# Planning Services Sign Permit Review Form

Date of Submittal	Application Number	Applicant	Landowner
10/10/2023 Revised 10/24/2023	SIGN2310-0001	Mattamy Homes LLC	Mattamy Homes LLC

Contact Person	Seth Elliot	Contact Number	919-384-6717
Sign Location	NW Corner of Denali Dr. and Ennis Rd.	PIN Number	0682-28-1492.000

L-100

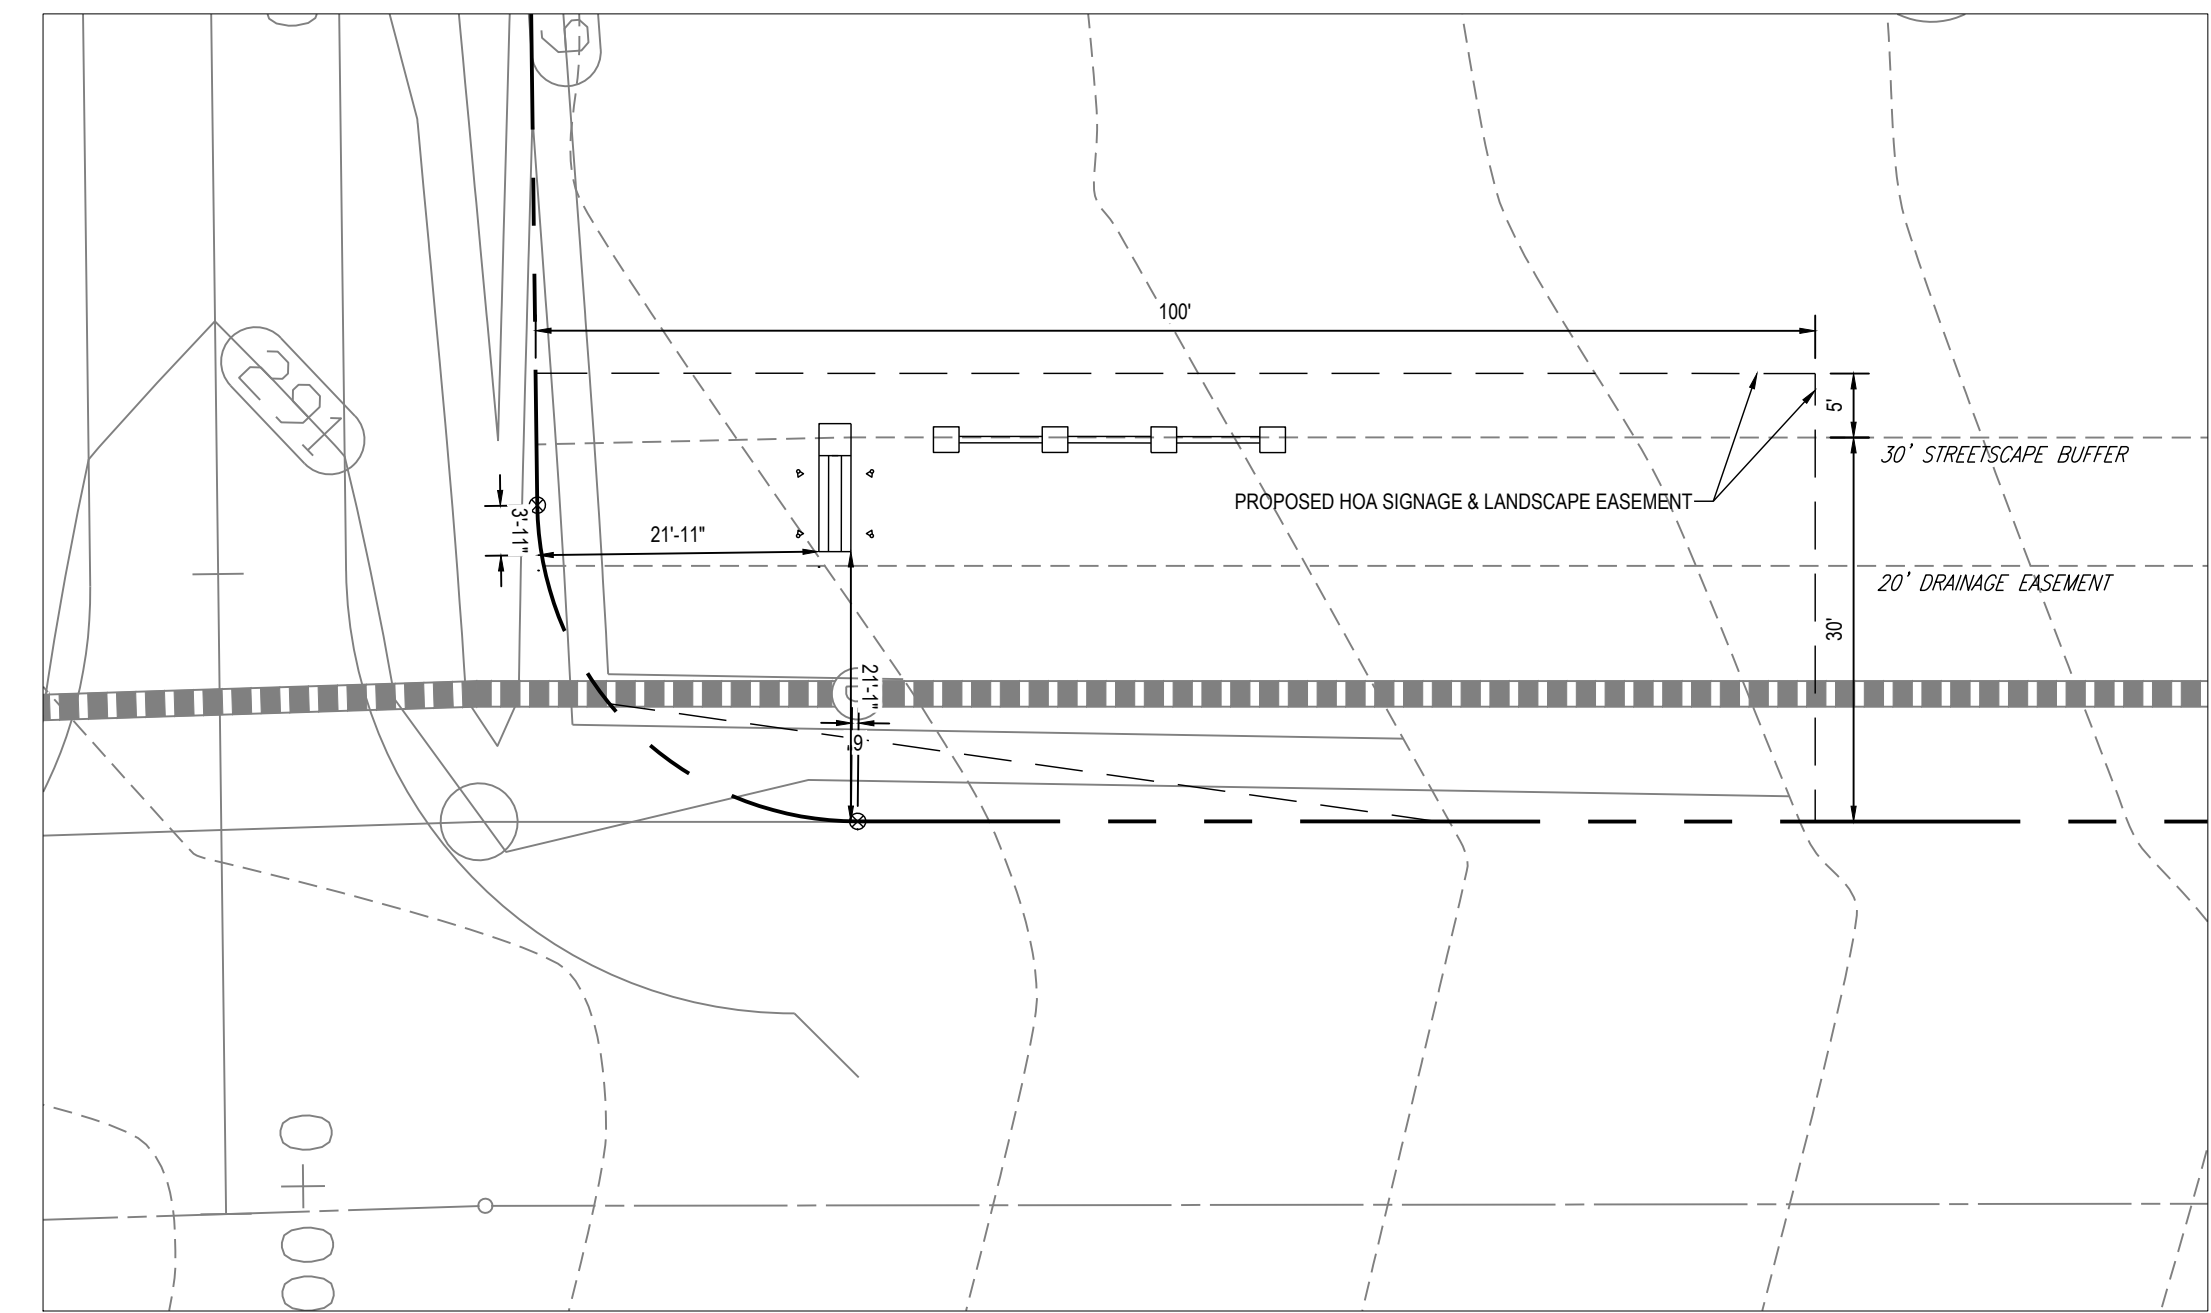
Comments	Fence cannot be attached to the sign and is not being reviewed or approved as a part of this sign permit. The fence must be located within the buffer area.
----------	---
